Marine
Management
Organisation

MMO Reference: DCO/2024/00007
Planning Inspectorate Reference: EN070009
Identification Number: 20049273

17 December 2024

Planning Act 2008, H2 Teesside Limited, Proposed H2 Teesside Order Deadline 5 Submission

Figure 1: Distances from River Tees HDD pits to MHWS. Information and images provided by H2 Teesside Limited.

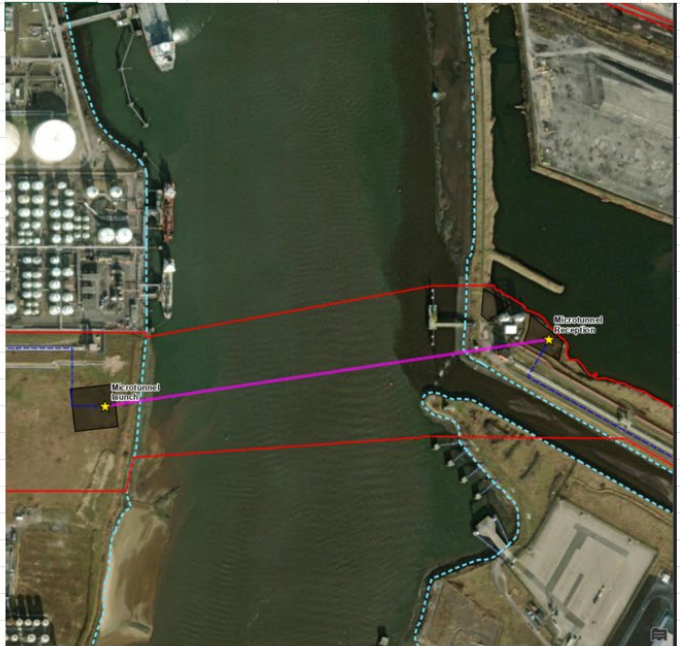
2.5.1 The MMO would like to reiterate for clarity that we are now satisfied that the launch and reception pit locations are above MHWS. The distances of which the Applicant has provided (REP4-013, ref MMO2) for the distances between MHWS boundary and the launch and reception pits are satisfactory. The MMO therefore considers the matter raised response regarding distances to marine receptors as resolved/agreed.
